WEST SUSSEX COUNTY COUNCIL CONSULTATION

TO:	Arun District Council FAO: Richard Castro-Parker
FROM:	Emma Avis, Highways, WSCC
DATE:	29 th October 2018
LOCATION:	DD Motors, Bersted Street, Bognor Regis, West Sussex
SUBJECT:	BR/242/18/PL Single storey side extension.
DATE OF SITE VISIT:	N/A
RECOMMENDATION:	☒ Advice ☐ Objection ☐ Modification ☐ No Objection ☐ More Information ☐ Refusal
S106 CONTRIBUTION TOTAL:	£N/A See below for breakdown.

Title
PROPOSED GROUND FLOOR PLAN

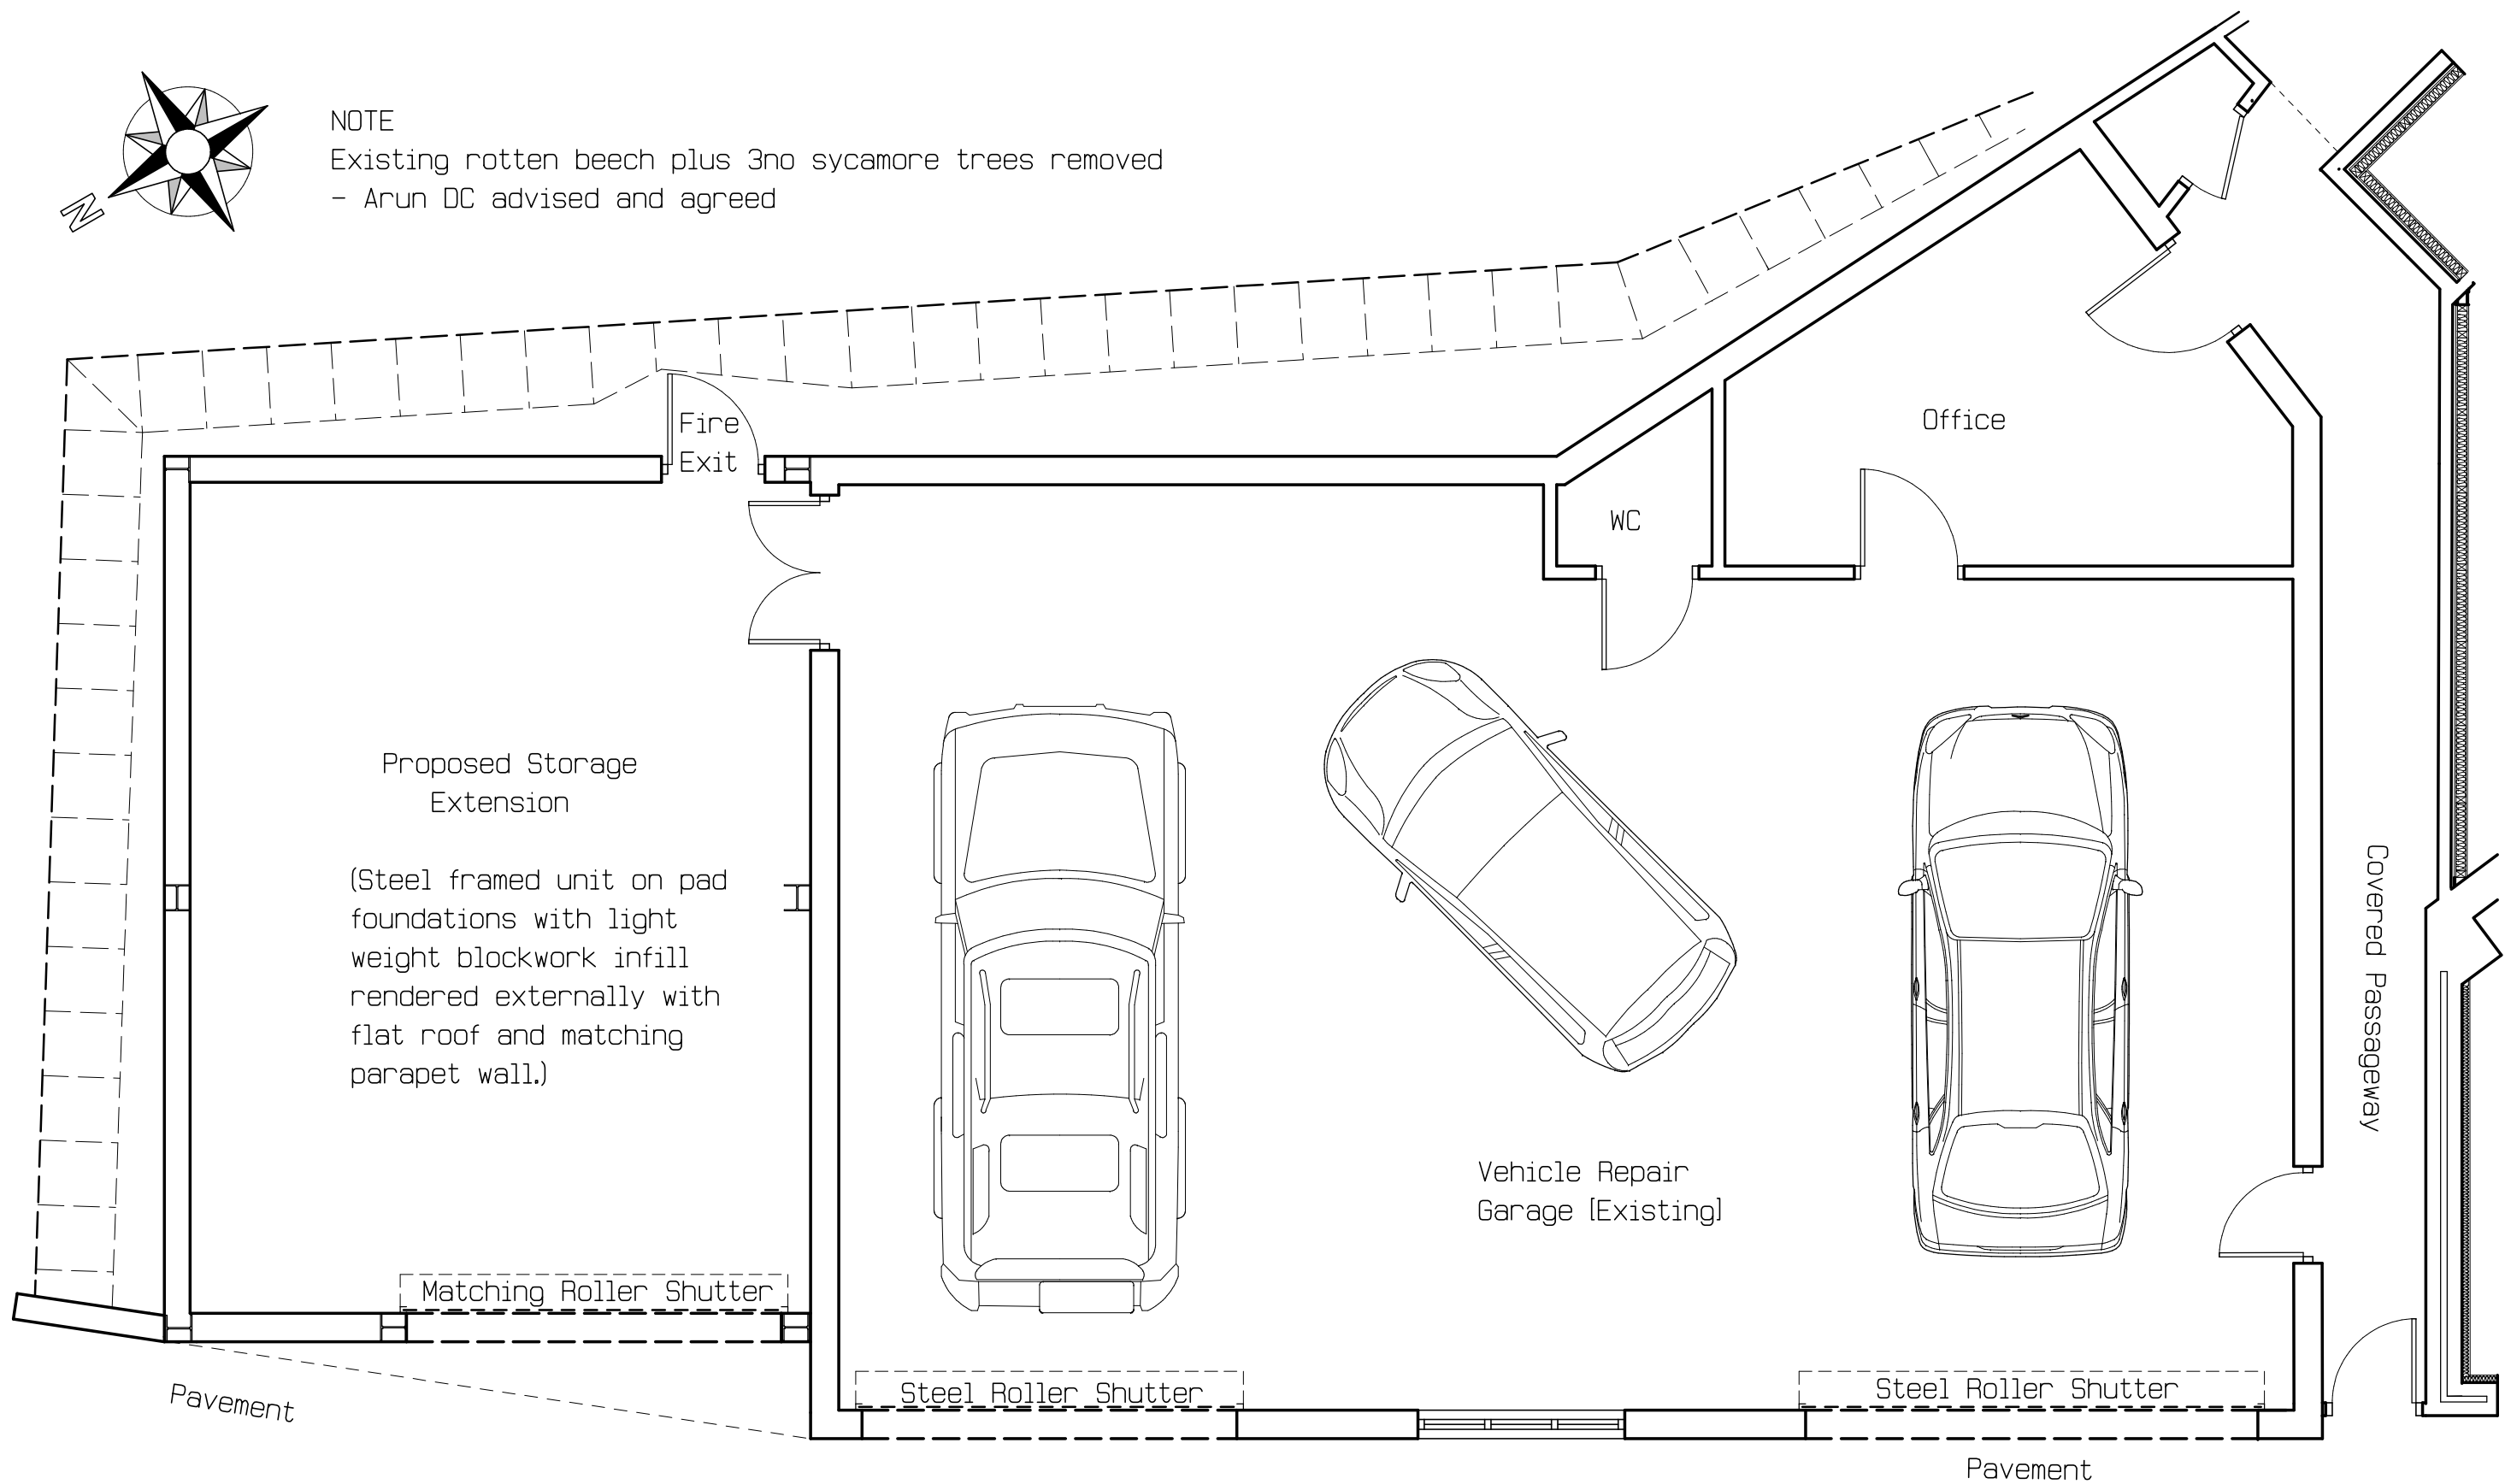
The proposal is for a small extension to the garage already on and operating from the site. It is clear that vehicles reverse into or out of the existing garage area/roller doors. There are no recorded incidents to suggest this is or has caused a highway safety issue. The addition of the small extension and additional roller door would not raise anyway highway safety concerns. The applicant will need to apply to the area highway office to have the kerb dropped in front of this new roller door.
